The Hon Robert Stokes MP
Minister for Planning and Public Spaces

6 November 2021

Snowy 2.0 – Main Works Modification (SSI-9687-Mod-1)

Horizontal Directional Drilling –
Marica West

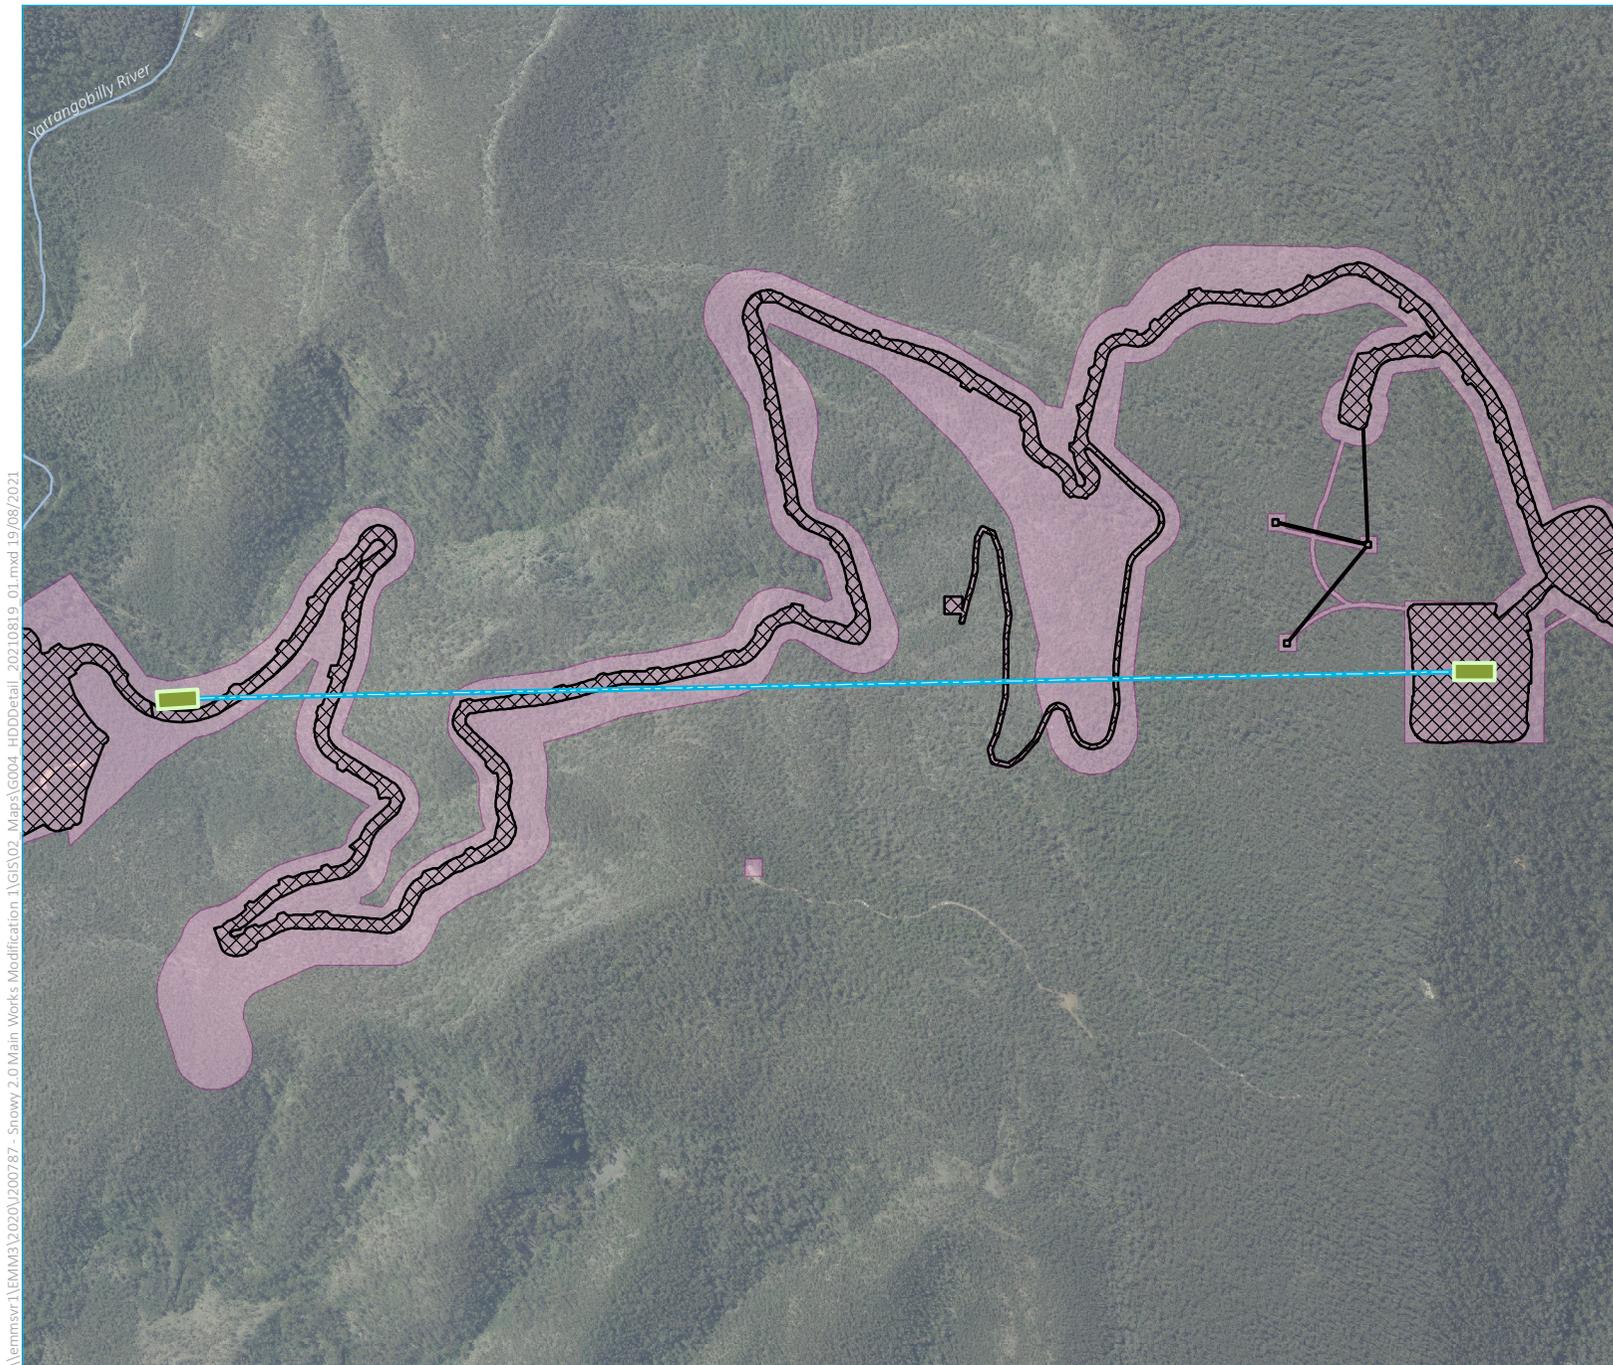
However, if the project continues, every opportunity should be taken to reduce its impact on Kosciuszko National Park. Accordingly, NPA offer conditional support for the proposed Horizontal Directional Drilling (HDD) between Lobs Hole and Marica as it involves less environmental impact than the alternate overhead lines.

NPA is concerned that the modification makes no mention of the electrical connection between Marica and Tantangara Reservoir. Our view is that this section should also be placed underground. We request confirmation of the proposed method for this section.
